DECISION DELEGATED TO DEVELOPMENT MANAGER

Application No: H09-0141-21 **Applicant:** Mr & Mrs D Wilson
Proposal: Extension of existing vehicular access
Location: 66 Spalding Road Holbeach Spalding
Terminal Date: 8th April 2021

SITE PLAN

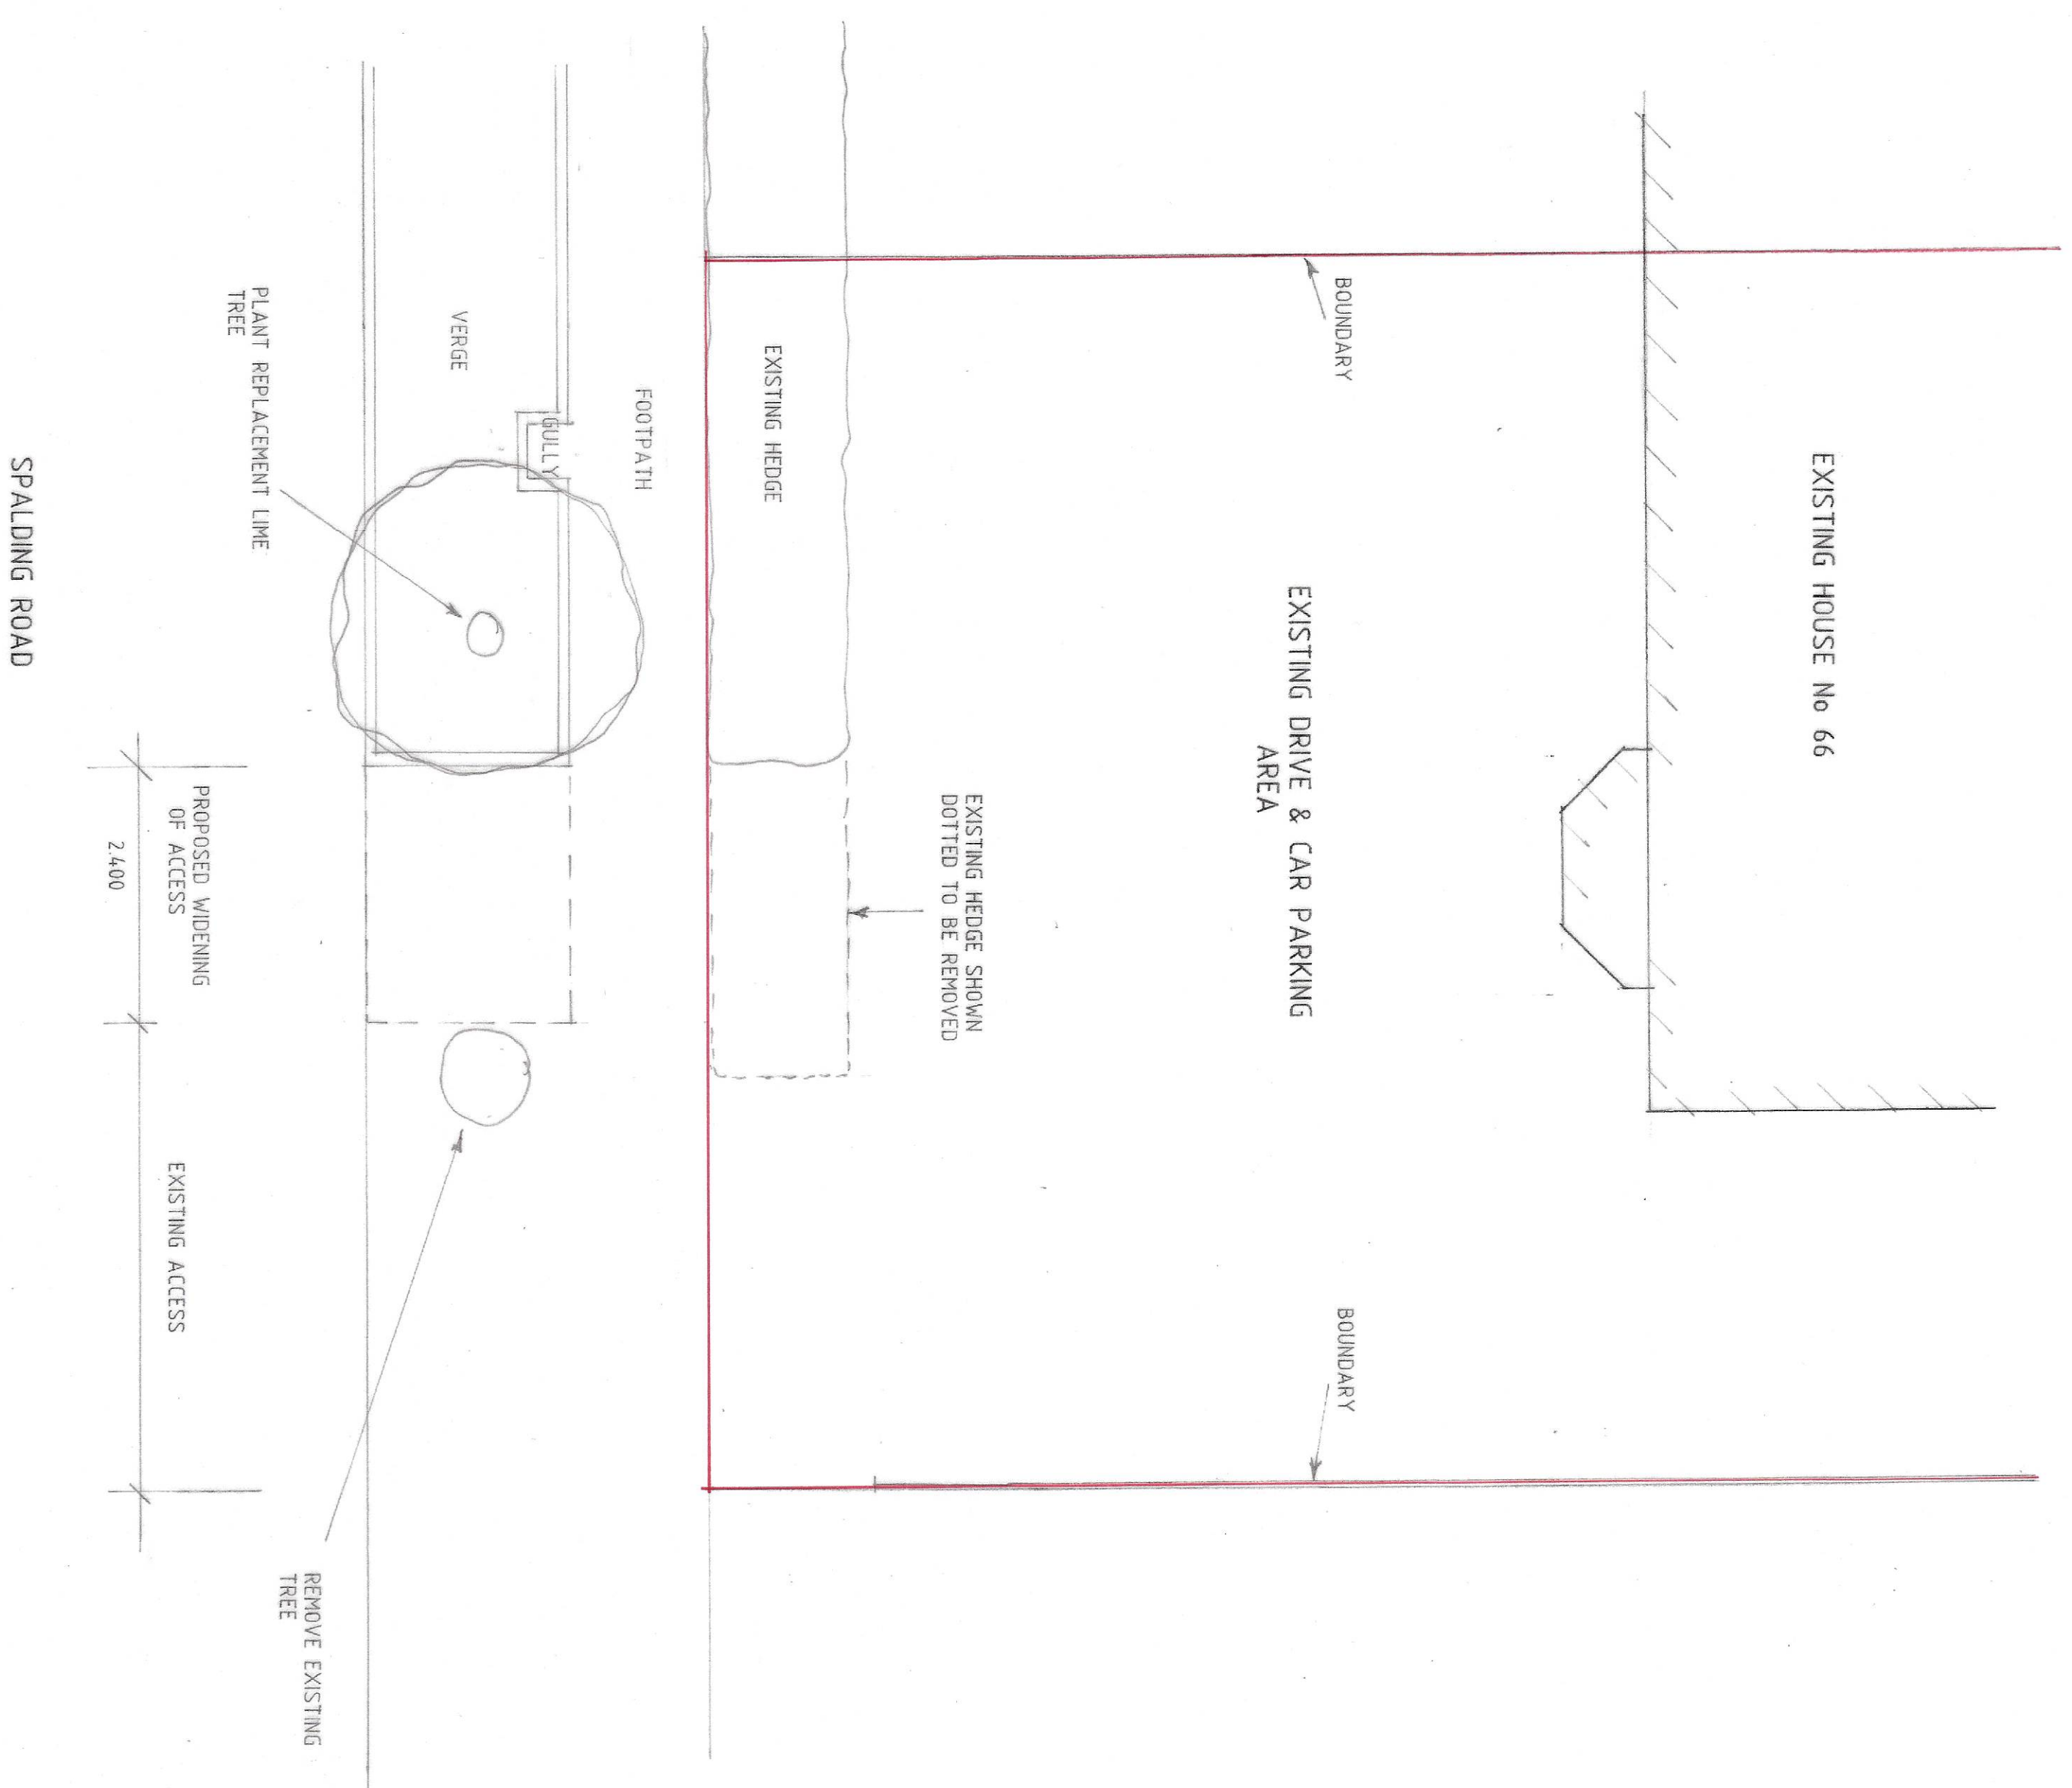
The proposed widening of the vehicular access entails the removal of the existing tree which appear immediately adjacent to the west. The tree is a lime pollard 6m tall, 70cm diameter, hollow base,

The width of the existing dropped kerb is up to 10 metres. The access serves the application property as well as the adjacent one to the east (No. 64). The crossover is of a of continuous form between both properties. No feature has been built to split the plots on the vehicular access.

The proposed alteration would increase the width up to 14 metres subject to the removal of the tree. The applicant justifies that the proposal is necessary to improve the highway safety standards which are claimed to be poor. The County Highway Authority has not indicated any approval with this statement. Their Arboricultural Officer pointed out that the existing arrangements are sufficient to ensure good safety standards for the motor vehicles users.

It is of case officer's opinion that the existing tree is a historic features of the street scene as many other mature trees in Spalding Road. It is unclear where the replacement tree would be planted. There is a streetlight a few metres to the west of the vehicular access and a new tree would be clearly in conflict with it by reason of proximity in accordance with the County Arboricultural Officer.
